## Comments from the Bicester Delivery Team, Cherwell District Council

19/01746/OUT – Bicester 10

JOB TITLE		CLIENT	
CATALYST BICESTER		ALBION LAND	
DRAWING TITLE			
WENDLEBURY ROAD FOOT/CYCLEPATH ENHANCEMENT WITH HEALTH AND RACQUETS CLUB			
SCALE	DRAWN BY	DATE	DRAWING No
1: 500@A1	RJM	03/05/19	19539-12-01
			REVISION
			B

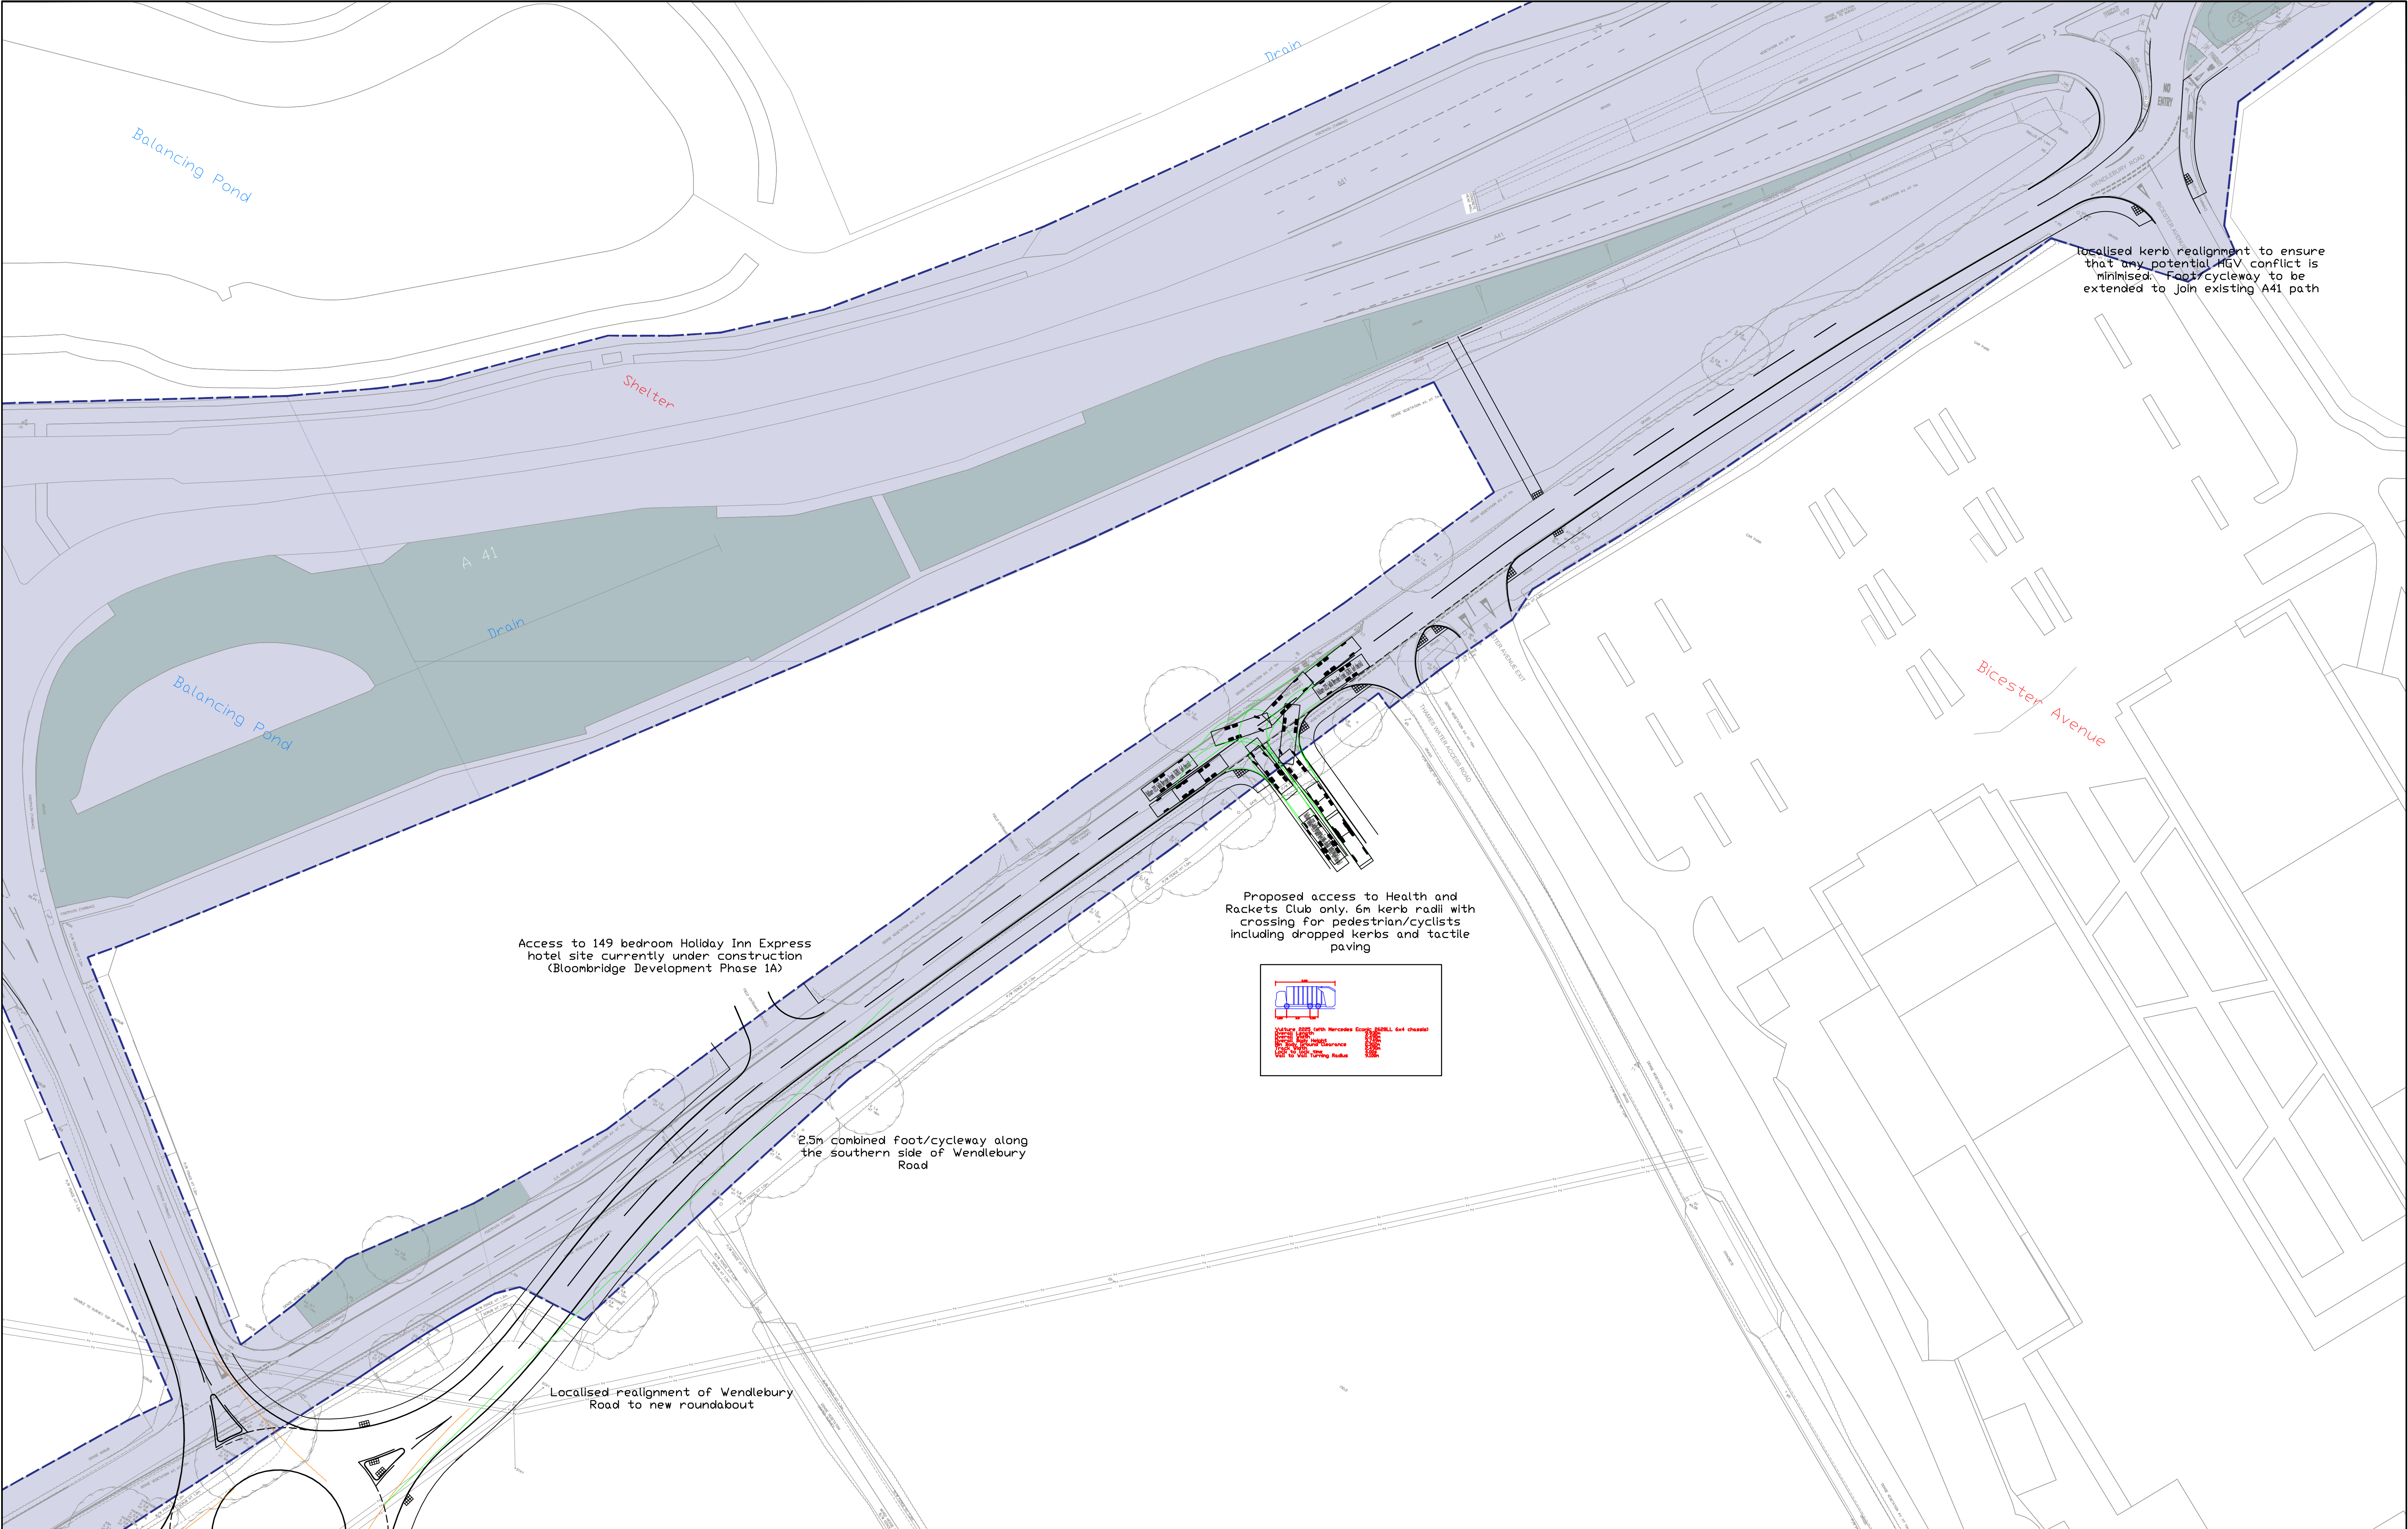
The proposed improvements include the provision of combined footway cycleway from the south of the site access roundabout along the eastern side of Wendlebury Road connecting with the commencement of provision at the Pioneer Way junction. The TA states that the proposed width is 3m (2.5m where there is insufficient room within the highway boundary. At each crossing point (access roundabout, David Lloyd Racquet Club, Thames Valley Water, service exit from Bicester Avenue and main access to Bicester Avenue) dropped kerbs and tactile paving are proposed.

In accordance with Oxfordshire Cycling Design Standards **priority should be given to the cycle way across each of the access points.** This is Sustrans route and will be identified for improvement within the forthcoming LCWIP. Despite stating that the path will be 3m, DTA's drawing number 19539-11-01 shows a 2.5m path. **A 3m path should be sought as a minimum.** A more detailed plan is required to show how the cycleway returns to the carriageway to the west of the access roundabout drawing number 19539-15-01 shows this ending with a dropped kerb perpendicular to the path alongside a marked section of cycle lane. A protected exit should be considered here.
